DECISION DELEGATED TO DEVELOPMENT MANAGER

Application No:	H13-0420-21	Applicant:	Enchantment Homes
Proposal:	Details of landscaping, boundary treatment, foul & surface water disposal and external boxes, gas flues & soil vent pipes (Conditions 3, 4, 5 & 6 of H13-0822-18)		
Location:	Adj. 29 River Lane Moulton Spalding		
Terminal Date:	16th June 2021

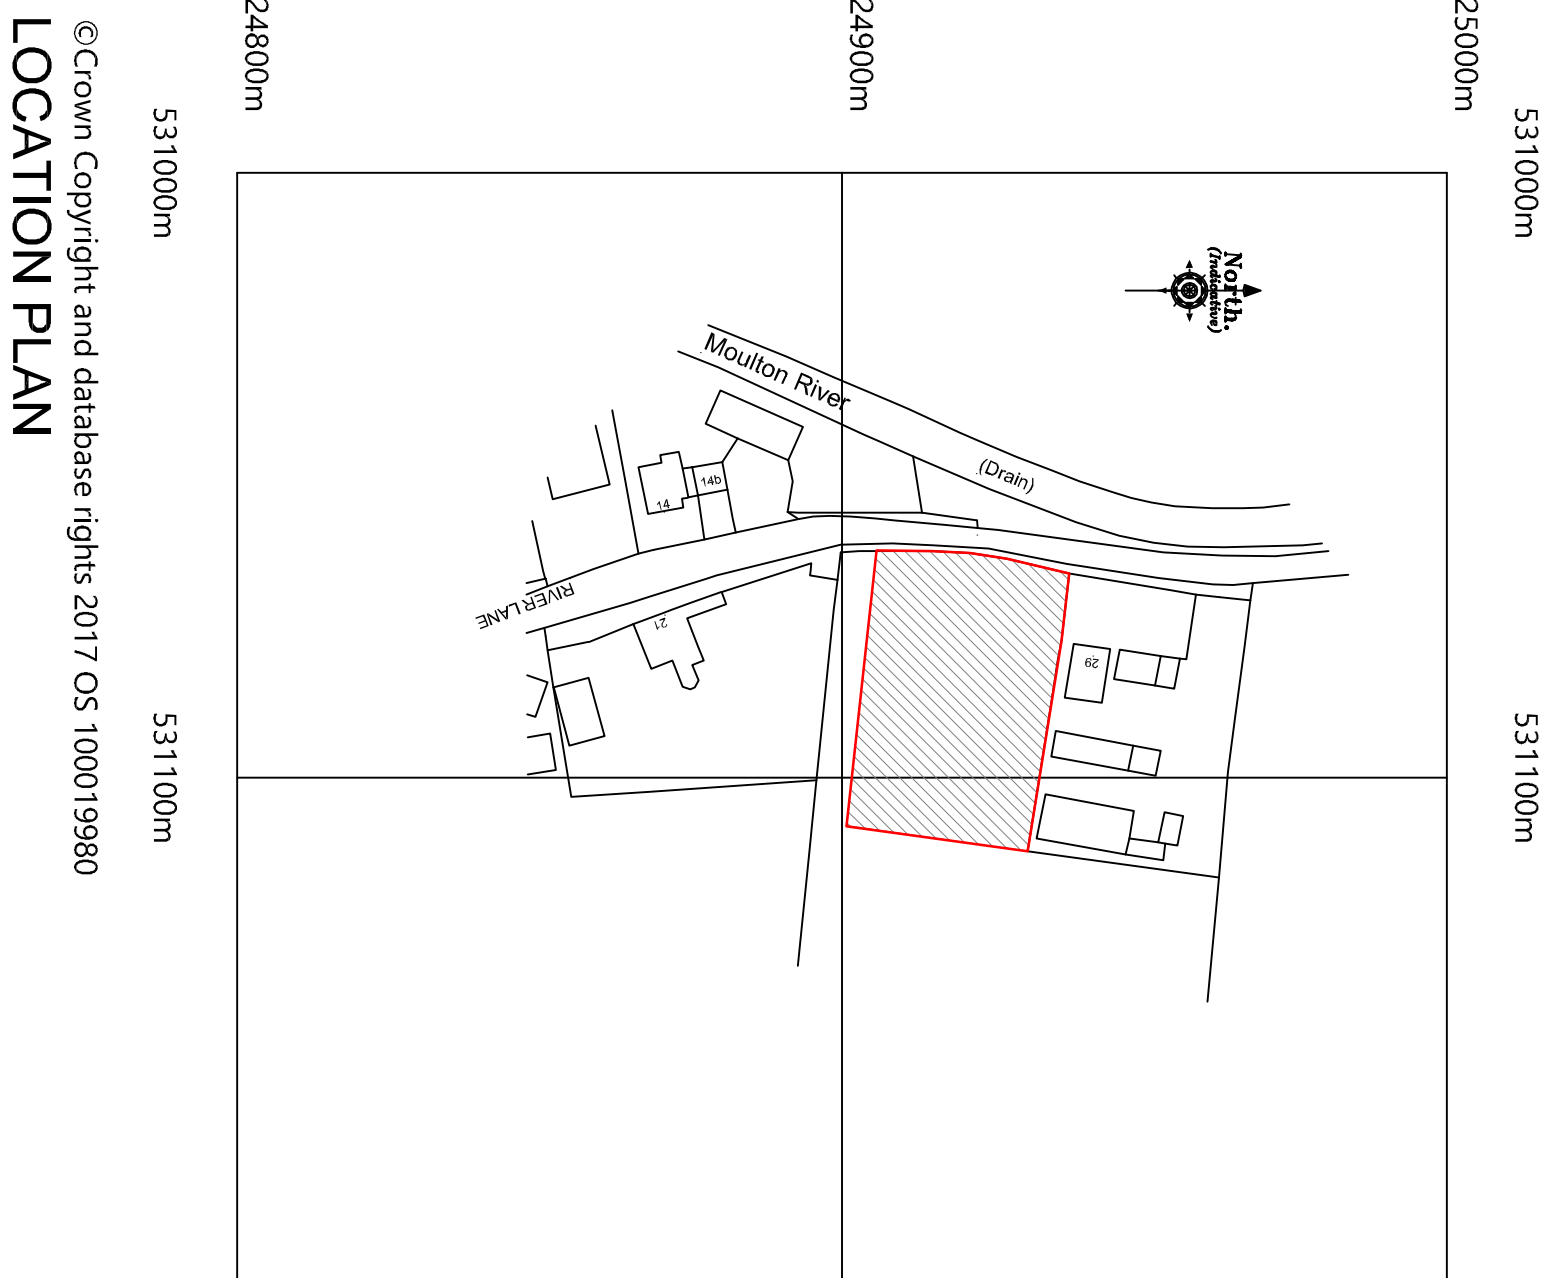
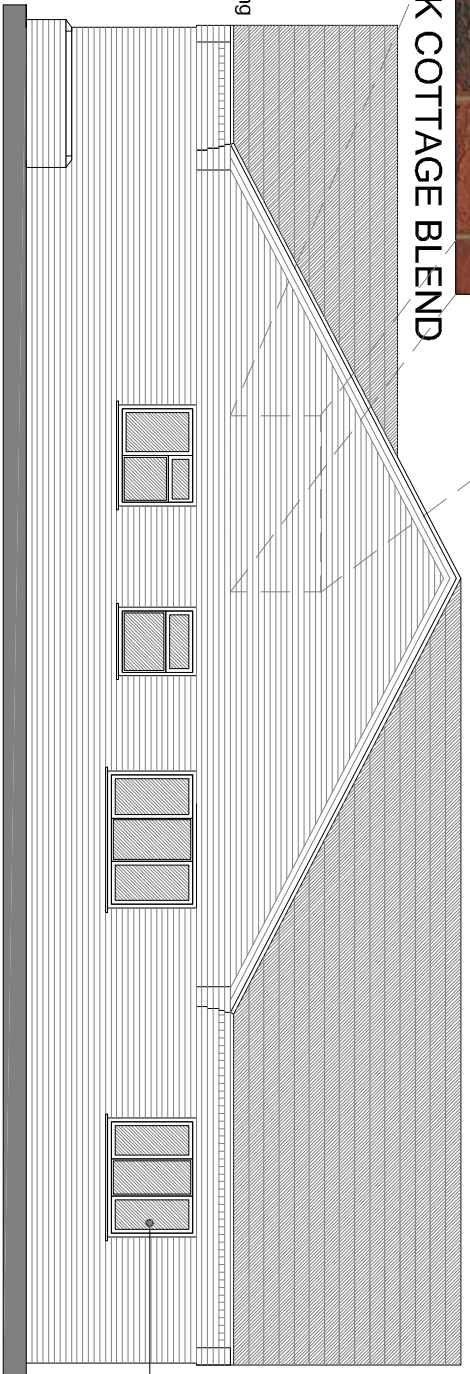
The proposed landscaping is fairly basic with a cherry tree to the front of the each bungalow. However, given the small nature of the plots and the siting of dwellings to the rear, the proposed landscaping scheme is considered to be appropriate.

The proposed 2 metre high feather edge fencing is to be sited to the side and rear of the site. Native hedging is to be sited toward the front side boundaries at a planted height of 600mm, growing to a height of 1.2 metres. The proposed boundary treatment is considered to be appropriate for the site

Foul water is to collect in a private drainage system, before being discharged to a mains sewer underneath River Lane. Soakaways are to be sited beneath the turning head locations of each property. There are no known permeability issues in this area that would preclude the use of soakaways.

An electricity box and soil vent pipe will be sited on the southern side elevation of Plot 1, and on the northern side elevation of Plot 2. The proposed domestic accoutrement locations are considered to be appropriate for the site.
